Application for removal or variation of a condition following grant of
planning permission. Town and Country Planning Act 1990.
Planning (Listed Buildings and Conservation Areas) Act 1990

Number	<input type="text" value="179"/>
Suffix	<input type="text"/>
Property name	<input type="text" value="Sydenham Police Station"/>
Address line 1	<input type="text" value="Dartmouth Road"/>
Address line 2	<input type="text"/>
Address line 3	<input type="text"/>
Town/city	<input type="text" value="London"/>
Postcode	<input type="text" value="SE26 4RQ"/>
Description of site location must be completed if postcode is not known:	
Easting (x)	<input type="text" value="535054"/>
Northing (y)	<input type="text" value="172241"/>
Description	<input type="text"/>

The demolition of the existing former Sydenham Police Station at 179 Dartmouth Road SE26 and the construction of a part three/ part four storey plus basement building to provide 15 one bedroom, 15 two bedroom and 3 three bedroom self-contained flats, together with the provision of 3 disabled parking spaces, 52 cycle spaces, associated landscaping and refuse storage.

DC/15/92798

Drawing title: **Proposed North and West Elevations**

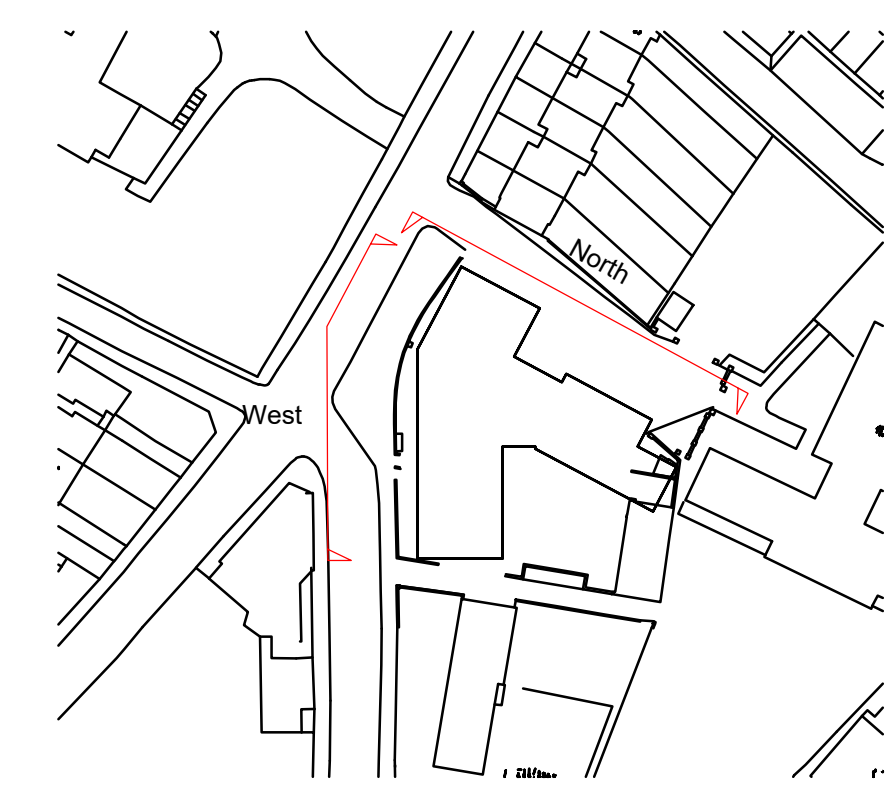
Condition 5 - We wish to change the approved facing material in areas shown as zinc cladding, colour anthracite to fibre cement cladding arranged in vertical panels and in a dark grey colour to closely resemble the approved material. This change is because if zinc is installed it is likely to be stolen due to it's current value and it's accessibility on this building. Also the proposed fibre cement panels are available with a relatively short lead in time which will allow the building to be completed on time.
